Application for a Non-Material Amendment Following a Grant of Planning Permission

Demolition of existing conservatory, glass pergola, and chimney. Two storey rear extension, first floor side extension, 2 no. dormers to front, partial garage conversion, extend existing rear dormer and alterations to fenestration and roof.

23/01385/HHA

Drawing Title:
ELEVATIONS AS PROPOSED

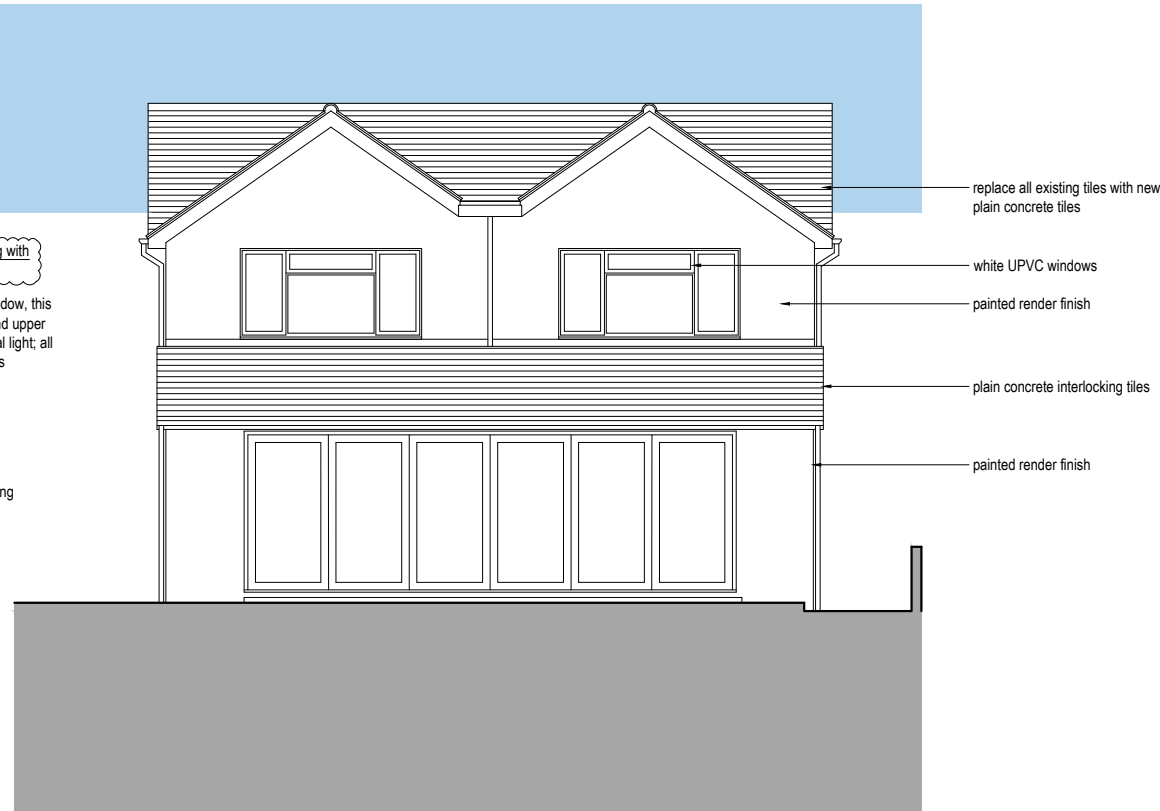
replace the cladding finish on the front elevation and front dormers with white render
